## Department of Primary Industries

### **Prestons Warehouse and Distribution Centre (SSD 7155) Comment on the Environmental Impact Statement**

Mitchell Isaacs  
**Director, Planning Policy & Assessment Advice**  
20/04/2016

Drawing:
SITE STAGING PLAN

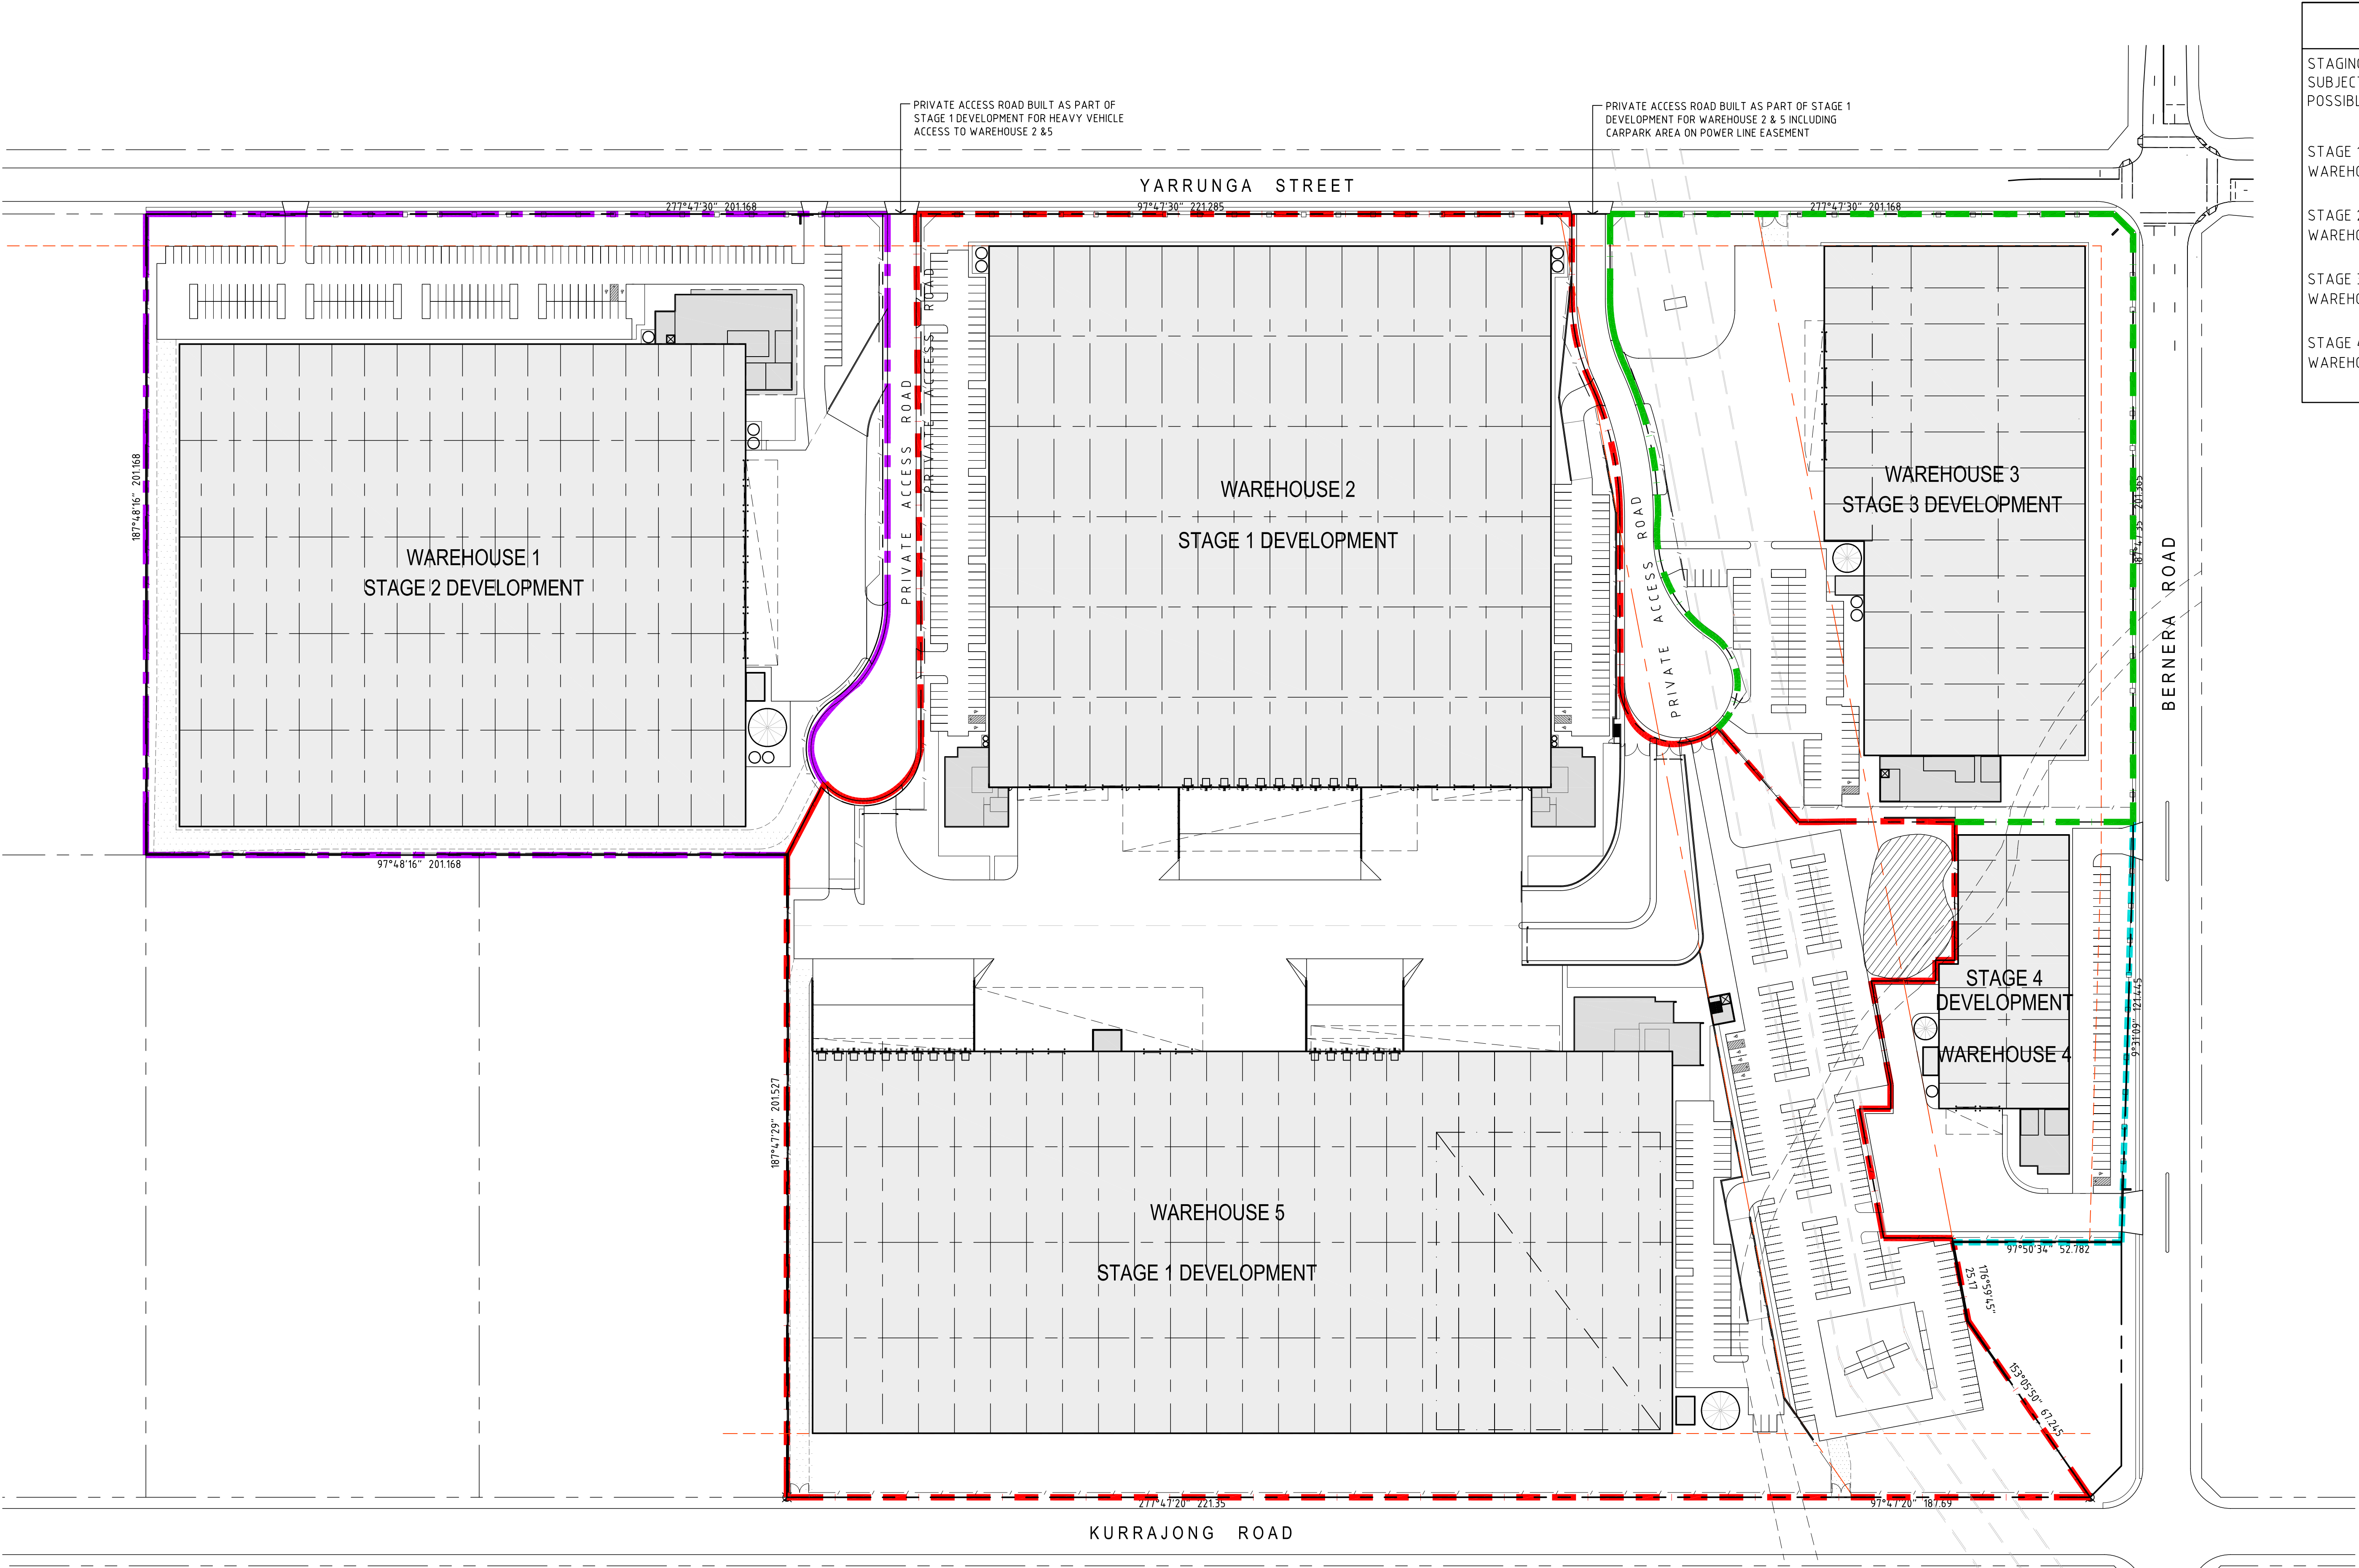
- From the review, DPI Water understands that the development of this facility will not impact on groundwater and surface water sources, and from the information provided, has no objection to the proposal.
- DPI Water notes that there is currently a first order watercourse in the south-eastern corner of Lot 20 DP1173483. In the EIS at page 26, Section 4.2 Site Layout, as well as all other plans within the EIS, it appears that this watercourse is going to be filled in/piped and covered by an at grade carpark, Warehouse 3 and Warehouse 4.

DPI Water highlights the importance of comprehensively addressing all options for the treatment of streams under the *Guidelines for Controlled Activities on Waterfront Land* (DPI, 2012). Any development must clearly assess the impacts of the proposal on the stream and provide best measures to minimise harm or mitigate the impact on the NSW State Rivers System.
